**Your Ref:** OWPC4604  
**Our Ref:** FG/165/14/HH 18-11-2014  
**Please ask for:**  
Mr D Sullivan

Single storey detached garage (resubmission following FG/132/13/).

29 The Poplars Ferring

Proposed floor & roof
plans & elevations

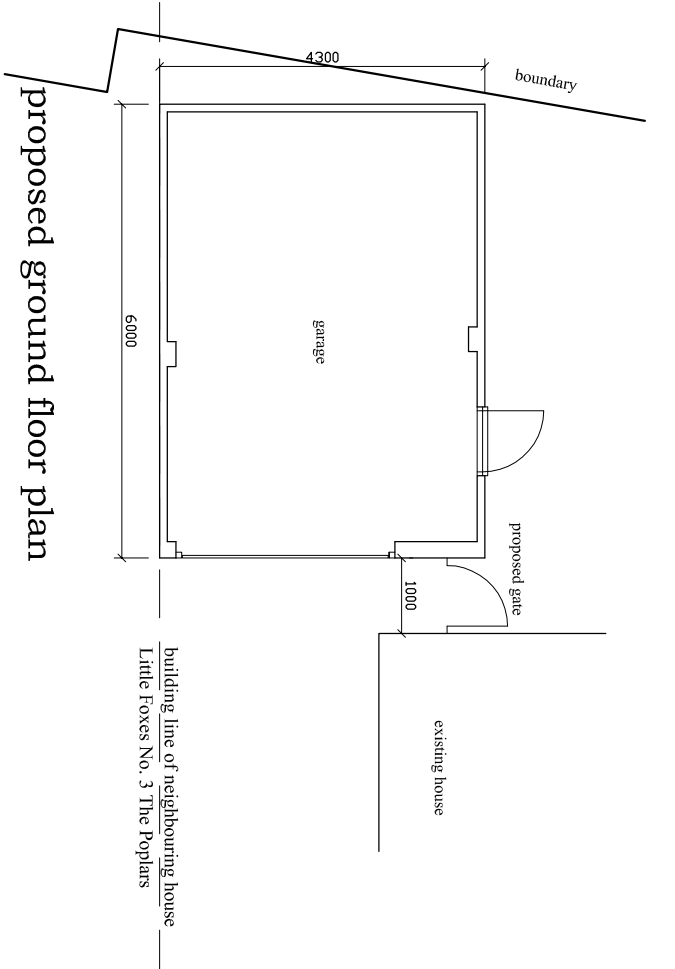
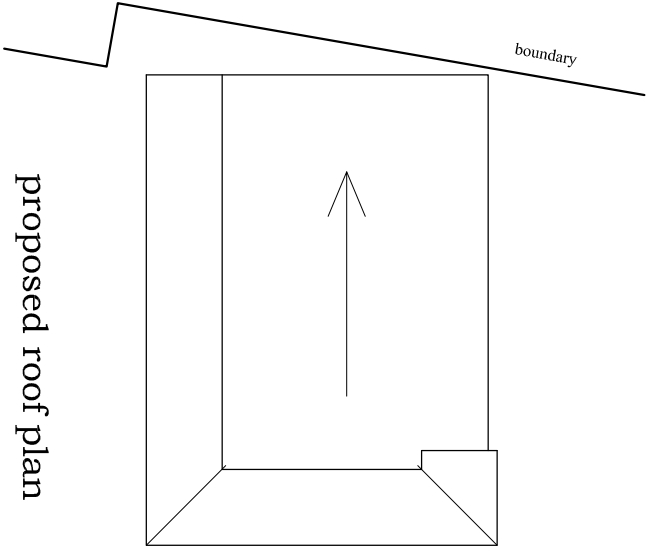
*Mr A Mackinnon SEEMS TO HAVE COME A LONG WAY FORWARD OF HIS OWN BUILDING LINE WHEN THERE SEEMS TO BE PLENTY OF ROOM TO MOVE THE NEW BUILD FURTHER BACK AT THE SIDE OF HIS PROPERTY AND KEEP IT IN LINE WITH HIS OWN BUILDING LINE*
